RE: **Tiryaki Apartments**
5550 Zia NE
Grading Plan Stamp Date: 11/21/19
Drainage report stamp date: 11/22/19
Drainage File: K18D105

Based on the submittal received on 11/22/19, the grading plan and drainage report cannot be approved for Building Permit and SO-19:

| ENGINEER'S SEAL 11/21/19 DAVID SOULE P.E. #14522 | TIRYAKI APARTMENTS 5550 ZIA NE GRADING AND DRAINAGE PLAN 1606 CENTRAL AVENUE SE SUITE 201 ALBUQUERQUE, NM 87106 (505) 872-0999 | DRAWN BY WCWJ |

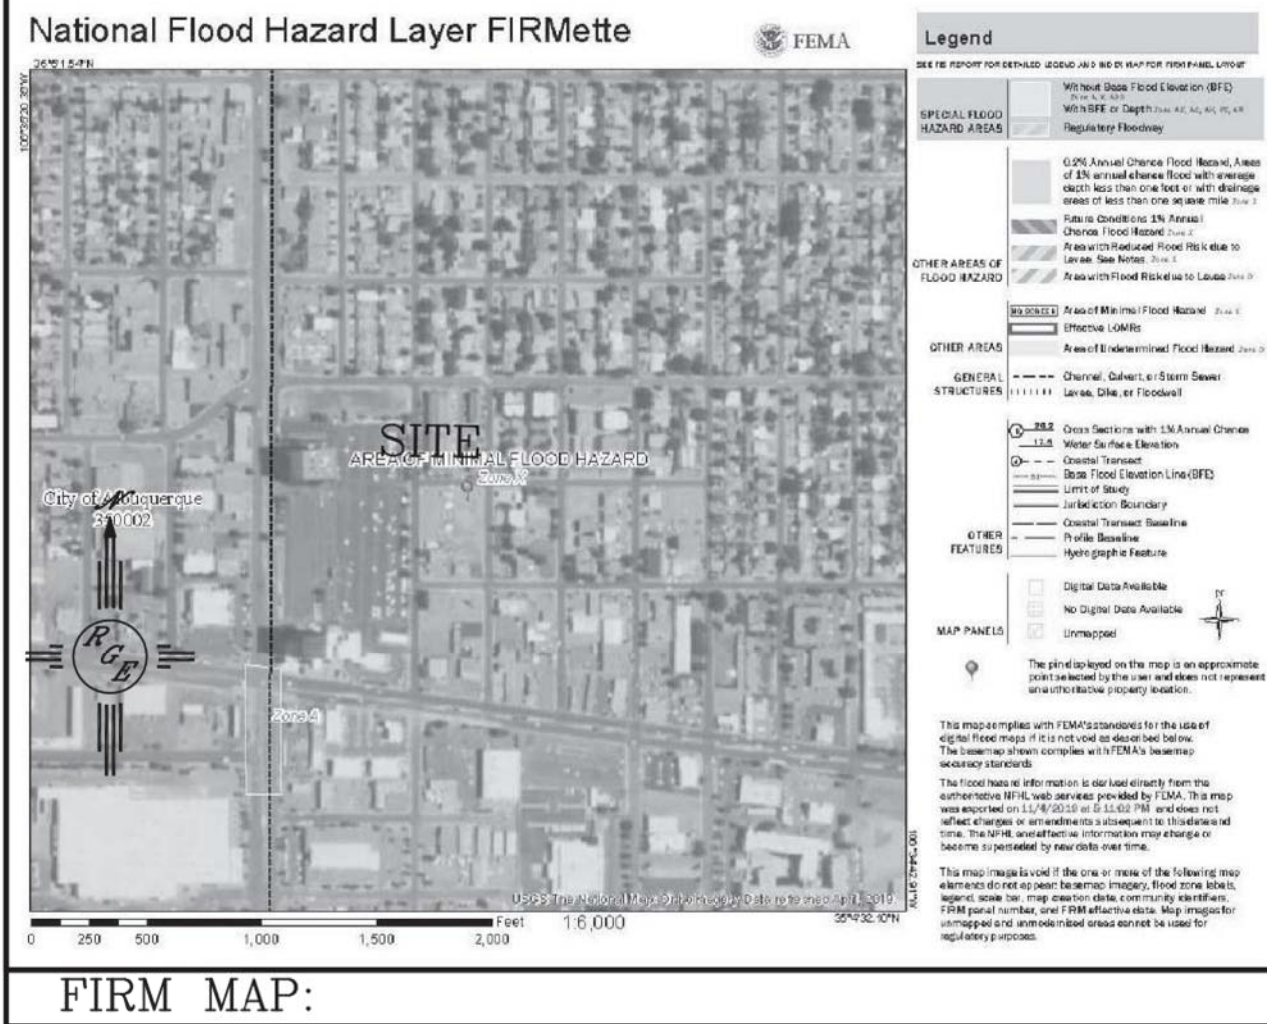
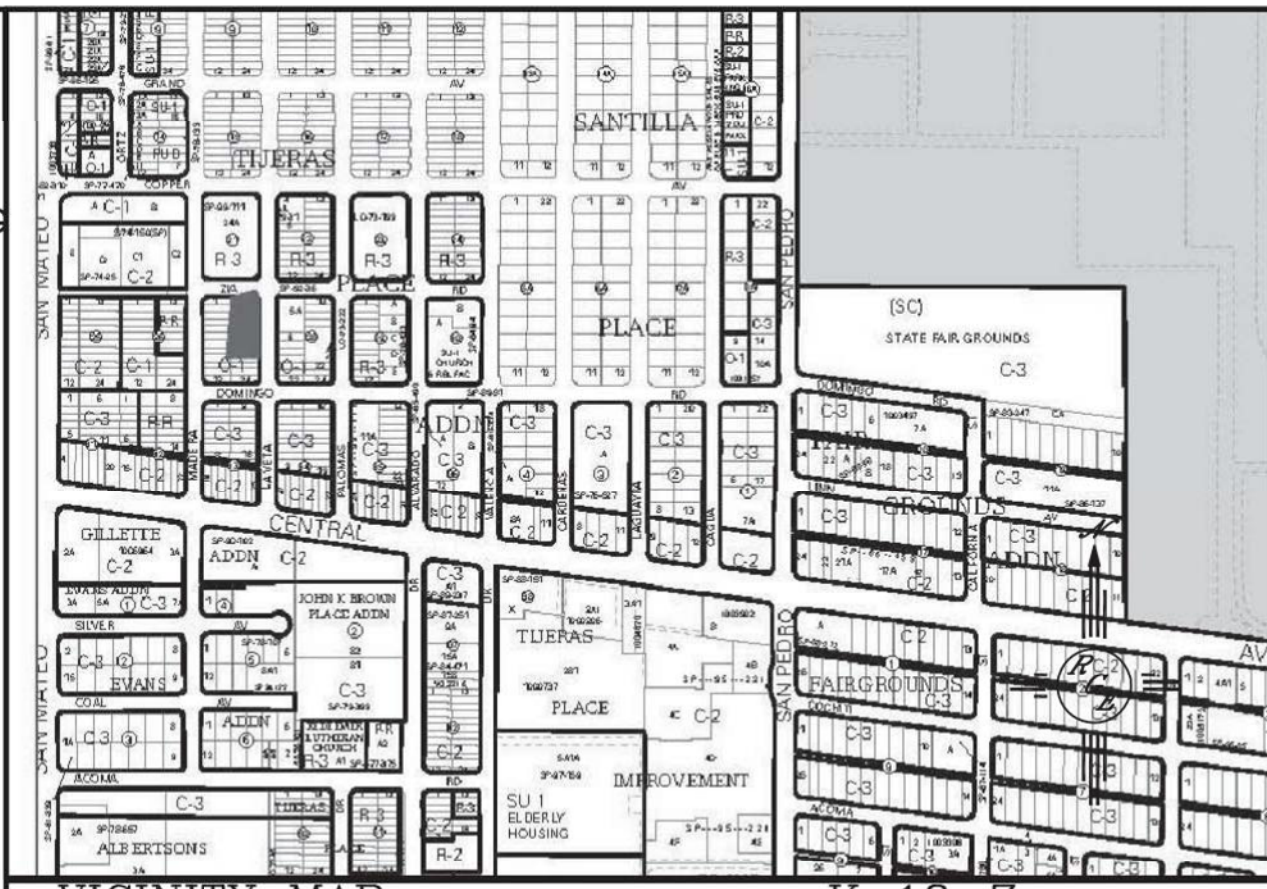
1. Payment in Lieu (Amount = $296\text{CF} \times \$8/\text{CF} = \2368 , per pg.5, drainage report) of onsite management of the SWQV must be made. Take three copies of the treasury deposit slip to the Treasury and then include one copy of the paid deposit slip when resubmitting. There is no resubmittal fee for this action; please include a copy of this letter when resubmitting to receive the reduced fee.

2. Engineer's Certification, per the DPM Chapter 22.7: *Engineer's Certification Checklist For Non-Subdivision* is required.
3. A Bernalillo County Recorded [Drainage Covenant \(No Public Easement\)](#) is required for the underground stormwater pond. The original notarized form, exhibit A (legible on 8.5x11 paper), and recording fee (\$25, payable to Bernalillo County) must be turned into DRC (4th, Plaza del Sol) for routing. Please contact Charlotte LaBadie (clabadie@cabq.gov, 924-3996) regarding the routing and recording process for covenants. The routing and recording process for covenants can take a month or longer; Hydrology recommends beginning this process as soon as possible as to not delay approval for certificate of occupancy.
4. The concrete swale must be inspected and approved by Storm Drain Maintenance (Augie Armijo at (505) 857-8607).
